# Rezoning Transportation Analysis

Petition Number: #2022-057

## Revision Log:

Date	Description
09-29-22	First Review (PDM)

CONCEPTUAL SITE PLAN		
PETITION NUMBER 2022-057		
Old Plank Road Site		
CITY OF CHARLOTTE, NC		
NO.	DATE	REVISION
1	10/17/2022	REVISED PER STAFF COMMENTS
2	11/23/2022	REVISED PER STAFF COMMENTS
3	12/16/2022	REVISED PER STAFF COMMENTS

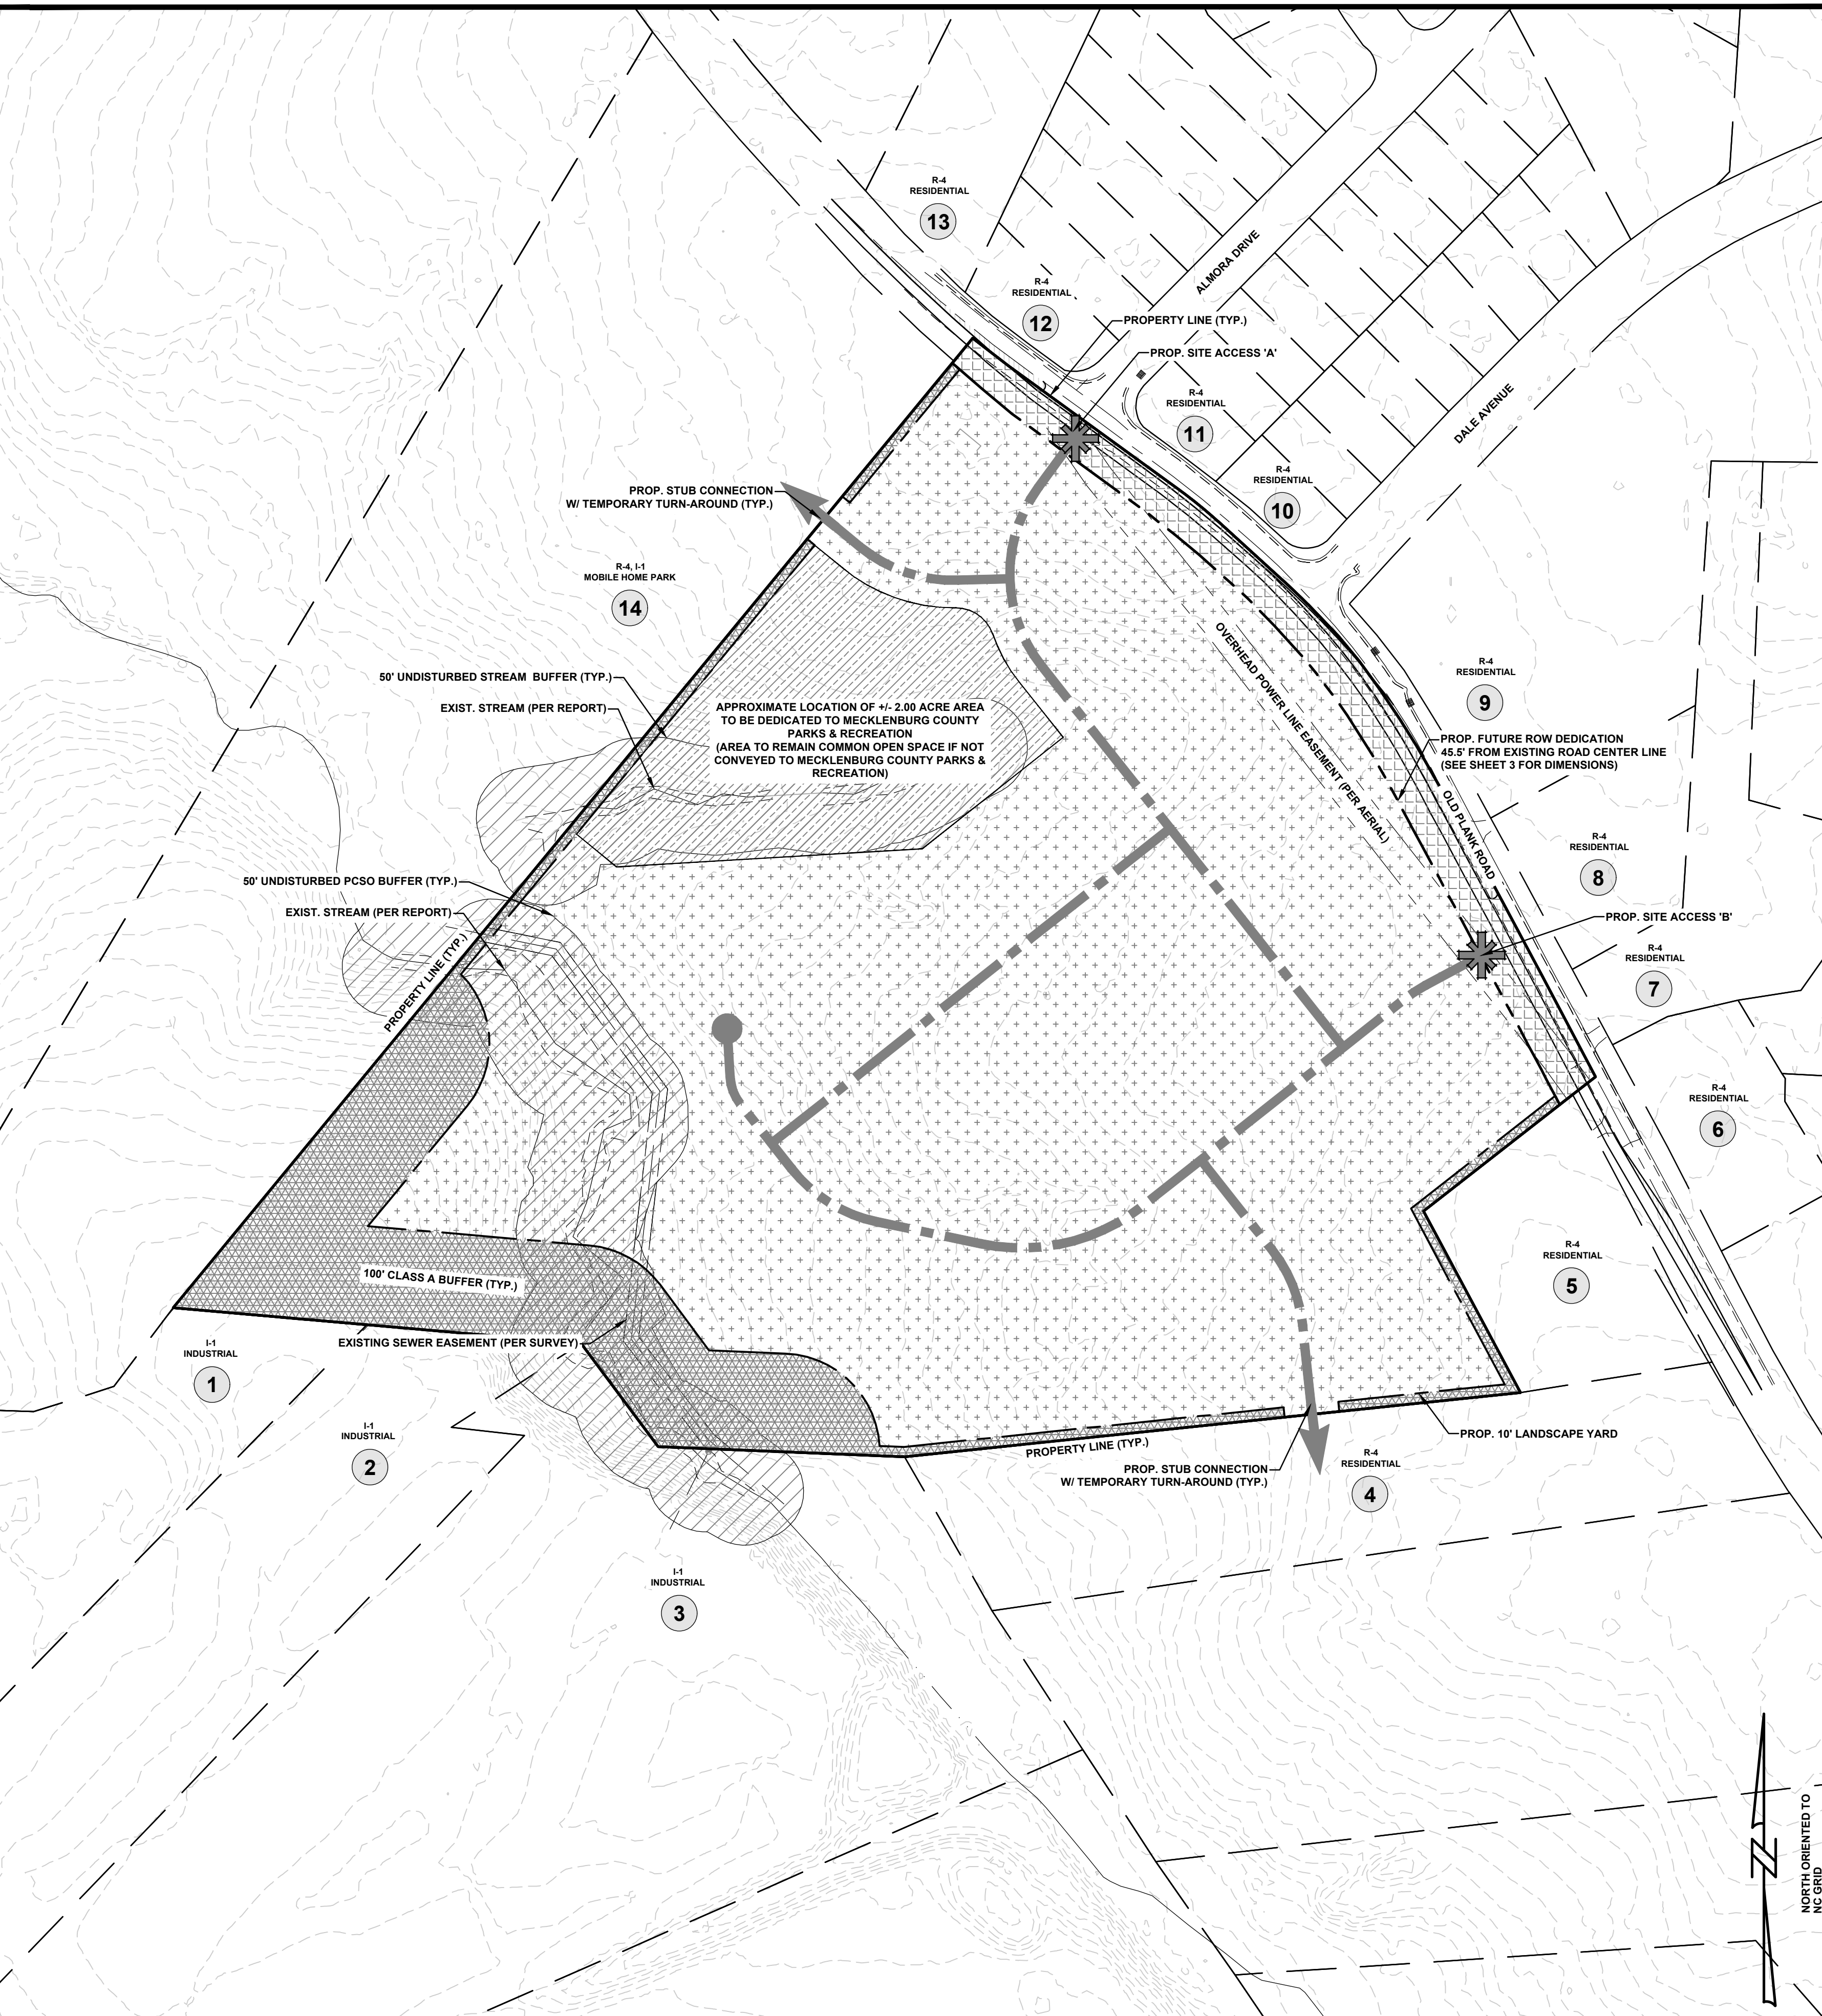
- a. **Old Plank Road:** Future location of the back of curb and gutter is 24-feet from the centerline of the roadway to the back of curb.

Label and dimension the curb and gutter from the centerline for Old Plank Road on the site plan.

- 3. Revise site plan and conditional note(s) to commit to dedicate 35-feet of right-of-way from the road centerline of Old Plank Road per the Chapter 20 ordinance. The site plan shall label and dimension the right-of-way from the road centerline. Provide and callout sidewalk utility easement located 2-feet from the back of sidewalk along Old Plank Road if located outside of the right-of-way.
- 4. Revise site plan and conditional note(s) to commit to construct an 8-foot planting strip, and 6-foot sidewalk along all public roadways. The site plan shall label and dimension both items from the back of curb and gutter and road centerline.

5. Revise site plan and conditional note(s) to commit to construct bicycle facilities along site frontage by locating the curb and gutter 24-feet from the center line and installing a 5-foot bike lane along Old Plank Road to meet the City Charlotte BIKE Policy.
6. Revise site plan and conditional note(s) to commit to the installation of left-turn lanes on Old Plank Road at the proposed site access points A and B. Each left turn lane should have a minimum of 100-feet of full width storage. Please be advised that additional widening may be required to install the left turn lanes.
7. Site plan and conditional note(s) revisions are needed to replace the proposed cul-de-sac bulbs to a temporary turnaround per CLSM 11.18B.

8. Revise site plan and conditional note(s) to label all roadways as public or private roadways. If the roadways will be public dimension the ROW of each road from the centerline.
9. Revise Transportation note 4 to include CDOT requests rights-of-way set at 2' behind back of sidewalk where feasible.
10. A site plan note specifying that all transportation improvements will be approved and constructed before the site's first building certificate of occupancy is issued as needed. The petitioner may phase transportation improvements if said improvements and phasing are explicitly described in site plan notes.

TECHNICAL DATA
 PETITION NUMBER 2022-057

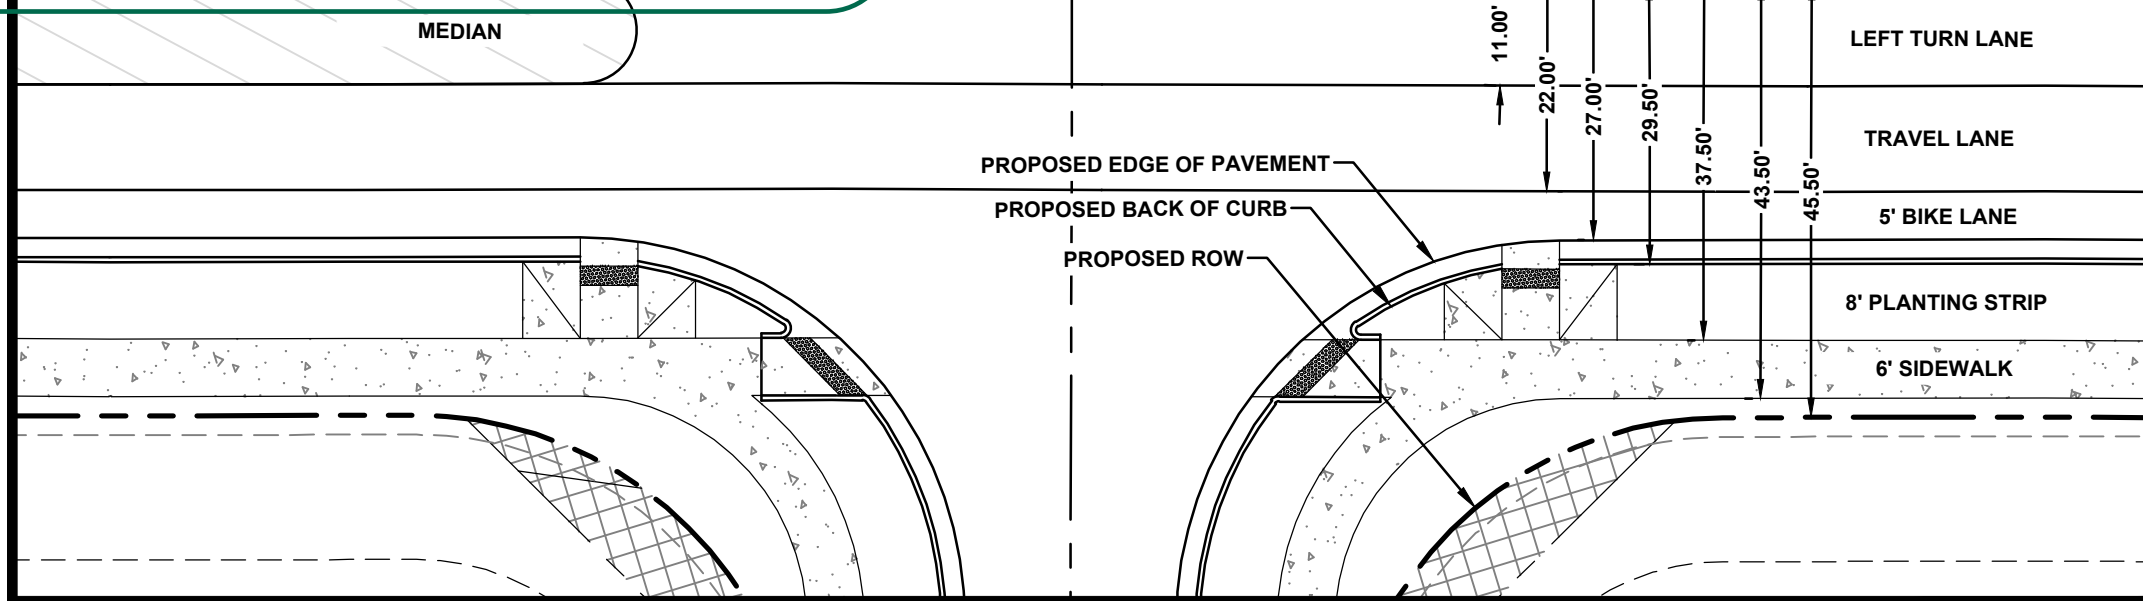
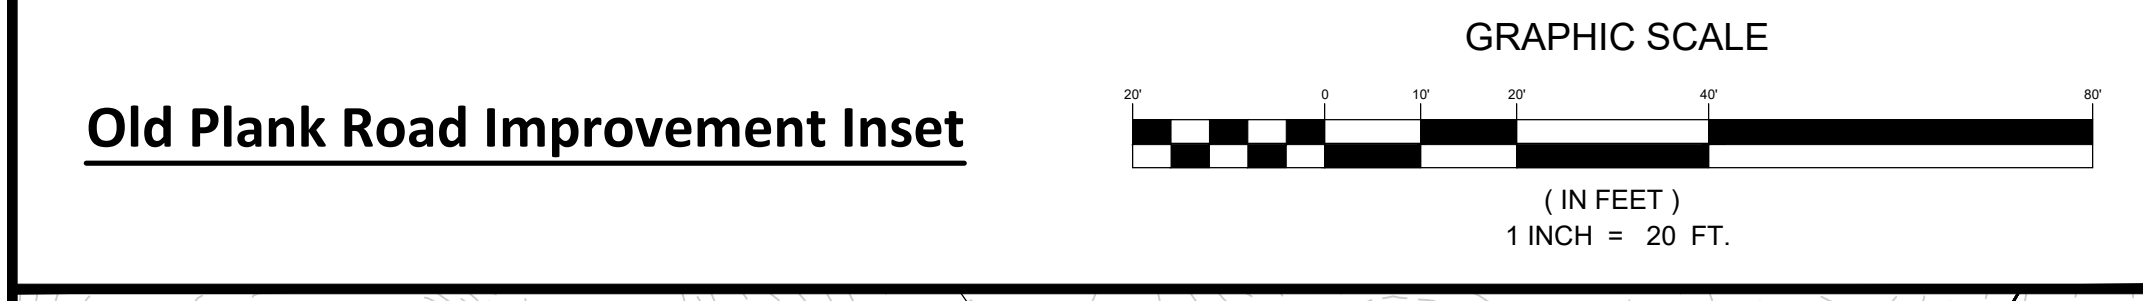
Remove Transportation Note 6 or clarify the full scope of the proposed phasing, including which improvements are proposed under each phase. Streetscape improvements to Old Plank Road, and the proposed access roads need to be constructed prior to the site's first building certificate of occupancy. The installation of the left turn lanes on Old Plank Road could be phased if desired.

Remove or clarify the proposed phasing.

5. Prior to the issuance of the first certificate of occupancy, Petitioner shall provide the proposed internal road network to sub grade and install curb, gutter, and storm pipe/drains.

6. Unless stated otherwise herein, the Petitioner shall ensure that all transportation improvements are substantially completed prior to the issuance of the Site's fiftieth (50th) building certificate of occupancy.
